**WELWYN HATFIELD BOROUGH COUNCIL  
ASSISTANT DIRECTOR (PLANNING)**

**Application No:** 6/2024/0337/HOUSE  
**Location:** 9 South Drive Cuffley Potters Bar Hertfordshire EN6 4HP  
**Proposal:** Retention of two dormers and erection of two dormers on each side facing roofslope  
**Officer:** Ms Ashley Ransome

**Recommendation:** Refused

DRAWING NO:
221103RD-05

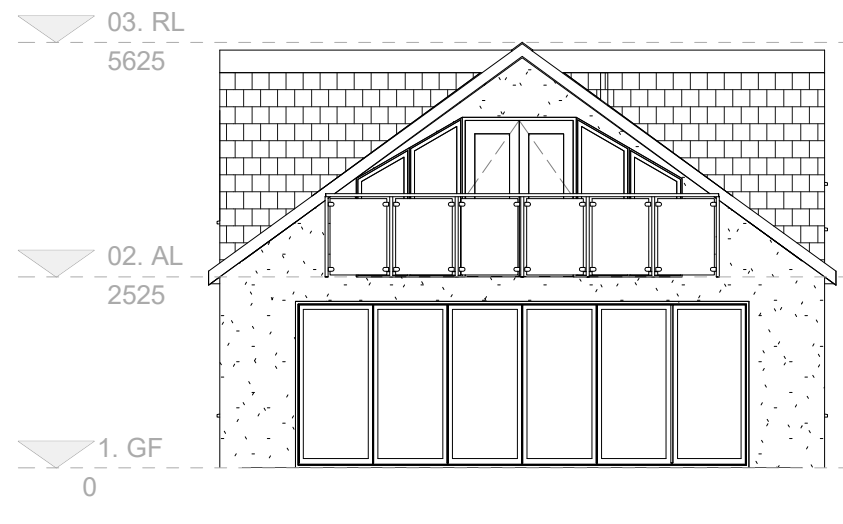
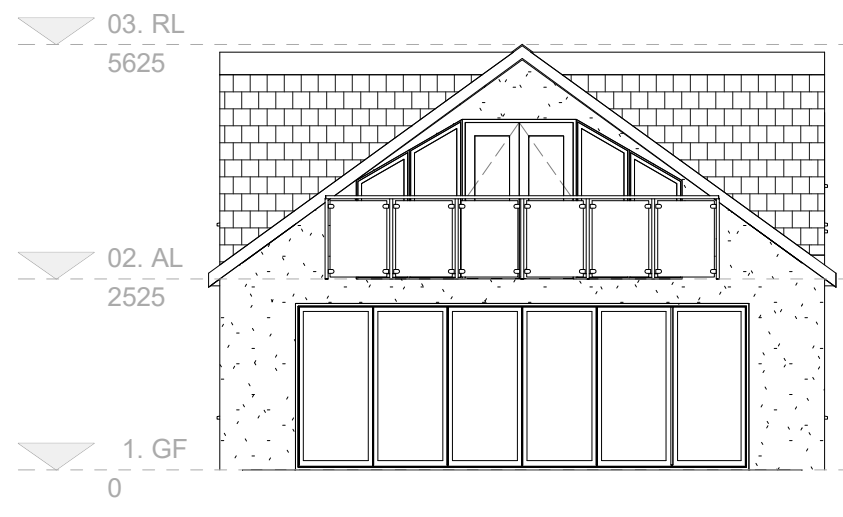
It is considered that the development is not acceptable in design terms. While the dormers do not exceed the ridge of the dwelling, they are set very minimally below the ridge, as well as only being minimally set up from the eaves. Furthermore, the rear facing dormer cheeks finish in line with the rear elevation of the dwelling. The dormers therefore occupy the majority of their respective roofslope, which includes the additional roofslope created by the recently completed rear extension and are further emphasised by the positioning of the dormers within the roofslope. The scale and design of the fenestration within the dormers is also out of keeping with the existing fenestration within the flank elevations of the dwelling.

DRAWING NO: 221103RD-07	REVISION:
----------------------------	-----------

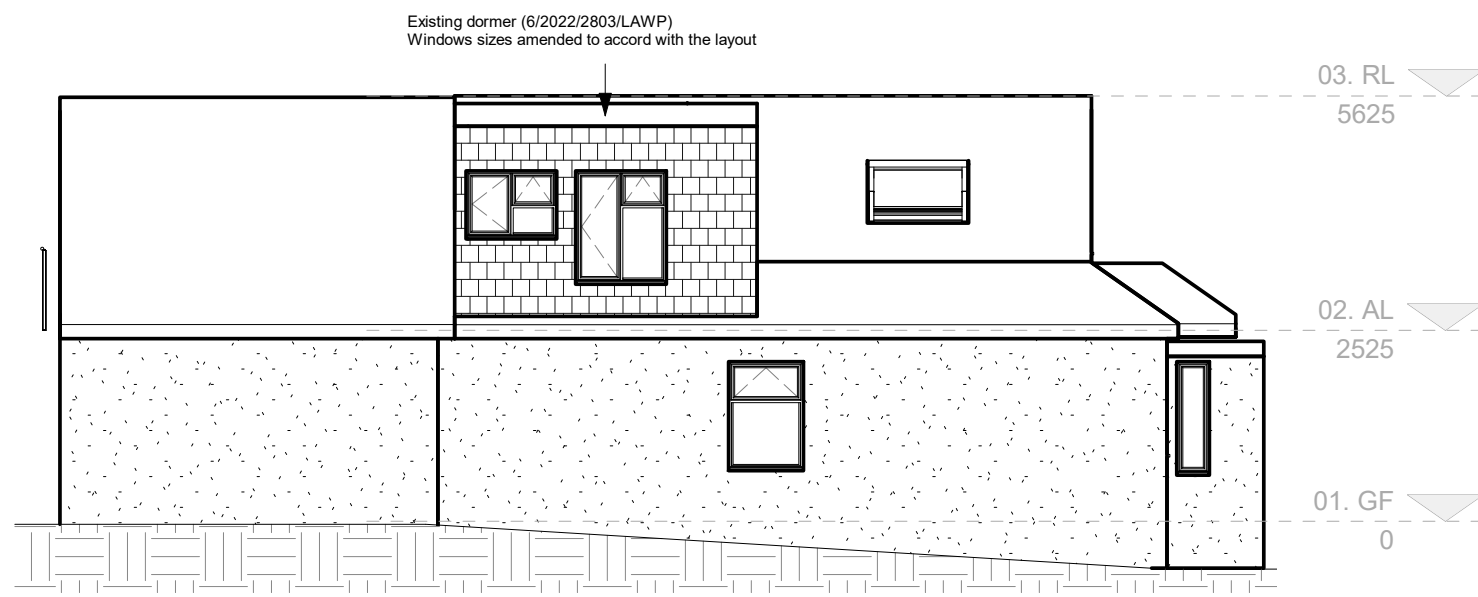
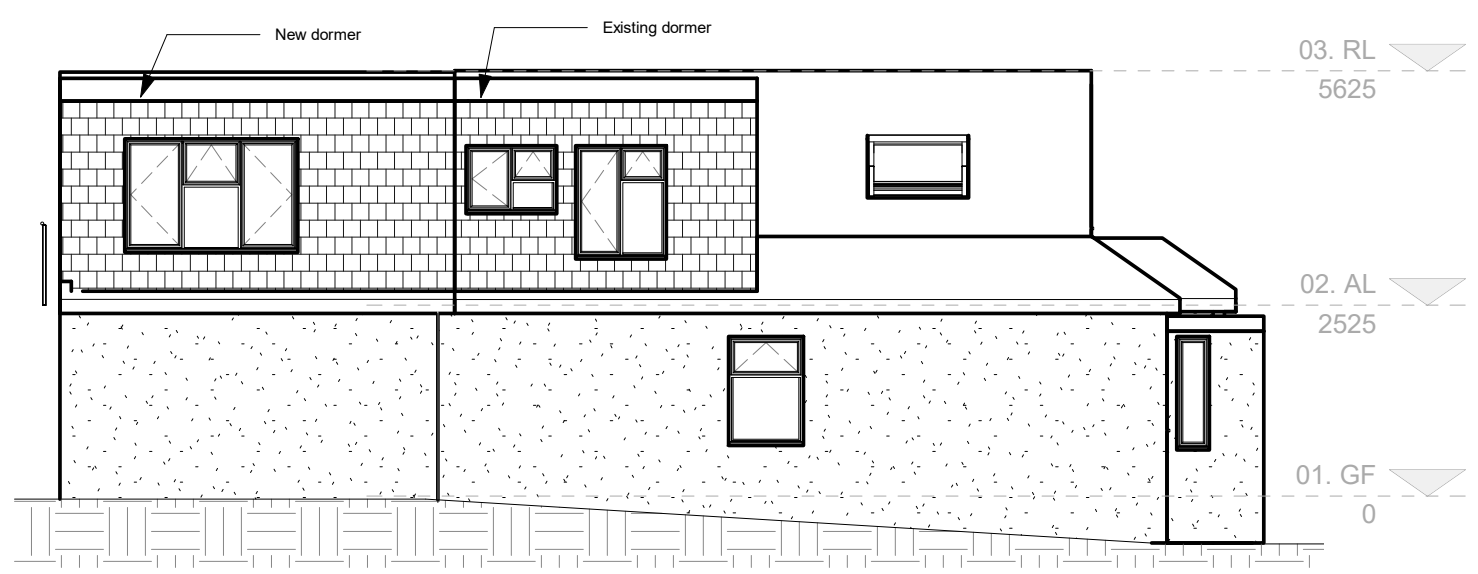
<p>The window within the dormer facing towards No.11 serves a bedroom. No.11 has rooflights within the roofslope facing towards the application dwelling. The dormer window would allow direct views into No.11's rooflights due to the positioning of the window within the dormer and orientation and positioning of the rooflights. However, no other windows serve the bedroom, and an obscured glazed window would result in poor internal accommodation for future occupiers.</p> <p>The dormer facing towards No.11 would therefore result in an unacceptable loss of privacy to the occupiers of No.11 as a result of overlooking towards the rooflights within the north facing roofslope of No.11. The dormer is therefore contrary to Policy SADM11 of the Welwyn Hatfield Borough Local Plan; the Council's Supplementary Design Guidance; and the National Planning Policy Framework.</p>
<p><b>Access, car parking and highway considerations</b></p>	<p>Paragraph 111 of the NPPF states that if setting local parking standards authorities should take into account the accessibility of the development; the type, mix and use of the development; the availability of and opportunities for public transport; local car ownership levels; and the need to ensure an adequate provision of spaces for charging plug-in and other ultra-low emission vehicles.</p> <p>Policy SADM12 of the Local Plan in regard to parking is informed by the standards that are set out within the Council's parking standards. The Parking Standards SPG use maximum standards that are not consistent with the Framework and are therefore afforded less weight. In light of this, the Council have produced an Interim Policy for Car Parking Standards that states that parking provision will be assessed on a case-by-case basis and the existing maximum parking standards within the SPG should be taken as guidance only. This means that higher or lower car parking standards than those set out in the SPG can be proposed and determined on a case-by-case basis taking into account the relevant circumstances of the proposal, its size, context, and its wider surroundings.</p> <p>The development would result in the dwelling to have five bedrooms. A four or more bedroom dwelling in this location should provide three on-site car parking spaces.</p> <p>South Drive has experienced parking pressures as evidenced by car parking restrictions in the area in place from 11am – 1pm Monday to Friday.</p> <p>The application site benefits from an area of hardstanding to the front of the property suitable to park one vehicle. The site also features a shared driveway with No.11 which leads to a garage to the rear of the application site. Due to the shared driveway however, a further vehicle could not park within the site without obstructing access to the garage of No.11.</p> <p>Following a recent application under reference 6/2023/2531/HOUSE, the pre-existing garage has been converted. Due to extensions which constrained the site, it was considered in the previous application that the existing garage was not suitable to house a vehicle and therefore the existing garage could not have reasonably been considered to provide off-street parking. The site therefore relies on the existing driveway which previously provided one on-site parking space. Notwithstanding, as seen within the surrounding street scene, a number of other properties along South Drive have extended their</p>

2. The dormer facing towards No. 11 would result in an unacceptable loss of privacy to the occupiers of No. 11 and would therefore be contrary to Local Plan Policy SADM11; the Council’s Supplementary Design Guidance; and the National Planning Policy Framework.

DRAWING NO:	REVISION:
221103RD-04

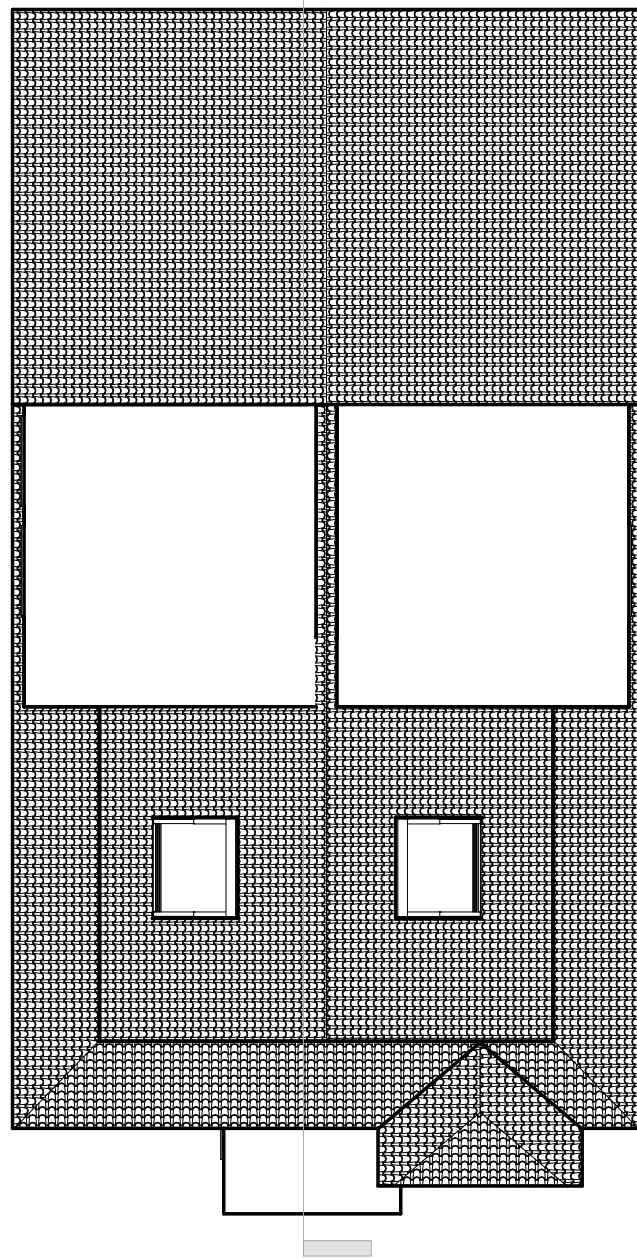
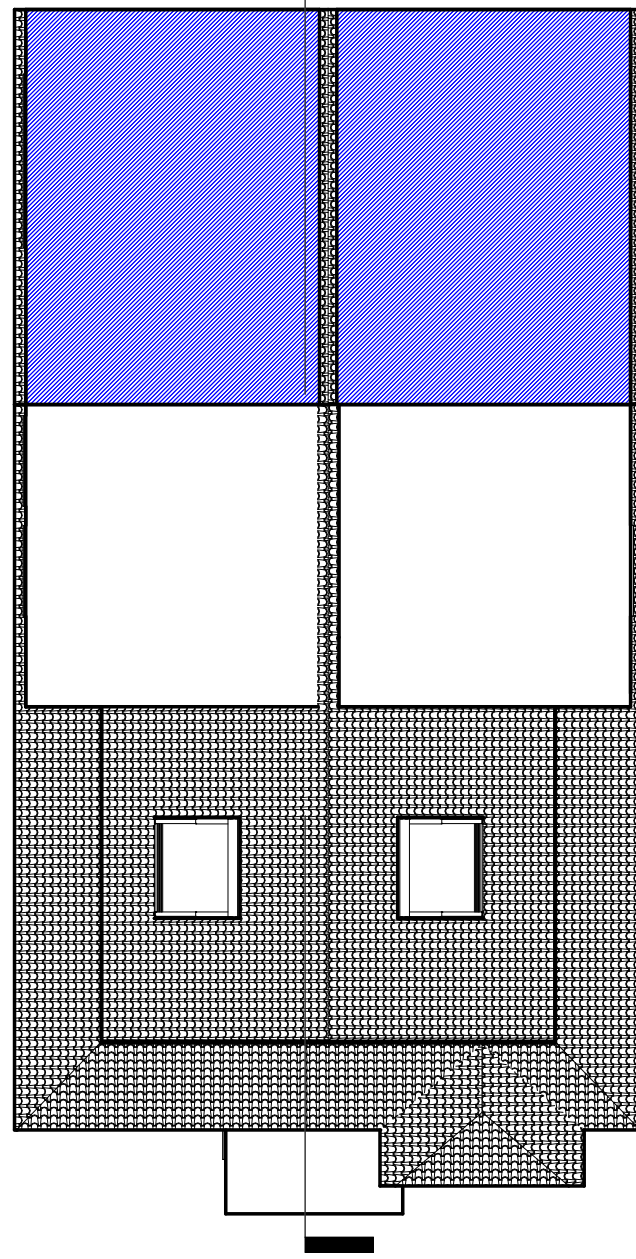
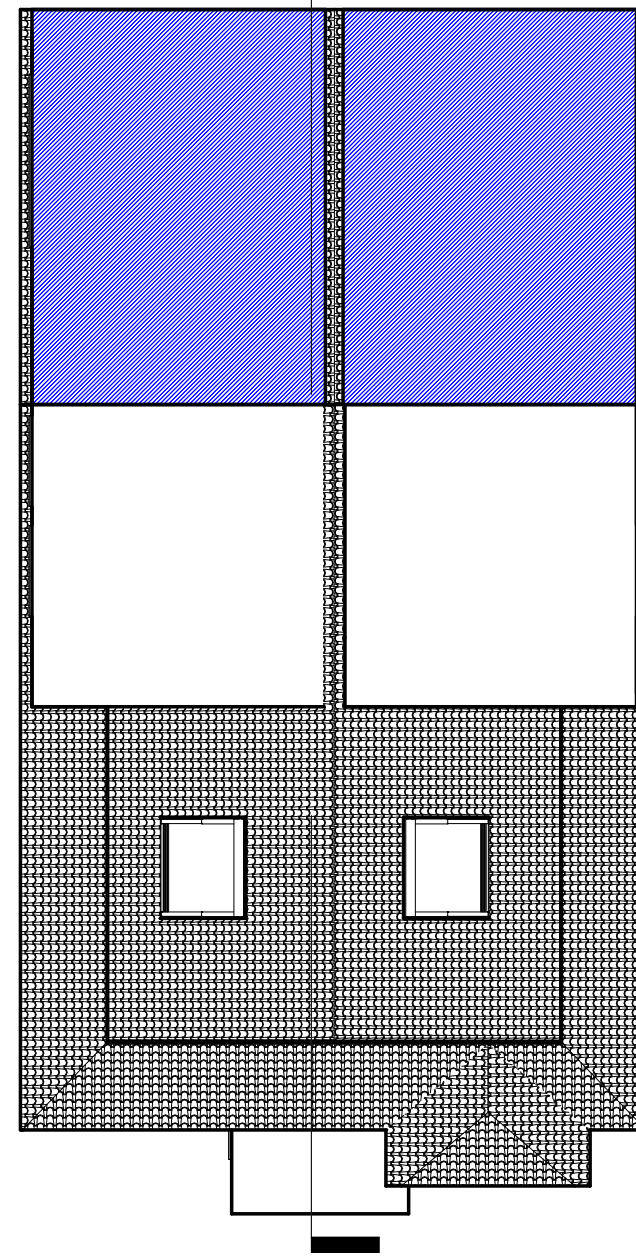
The dormers are substantial in size and scale, resulting in a development that is not subservient to the roof of the property. The dormers appear as an awkward and incongruous addition to the application site, as well as appearing unduly prominent within the street scene due to its significant bulk and mass, resulting in harm to the character and appearance of the dwelling and the surrounding area.
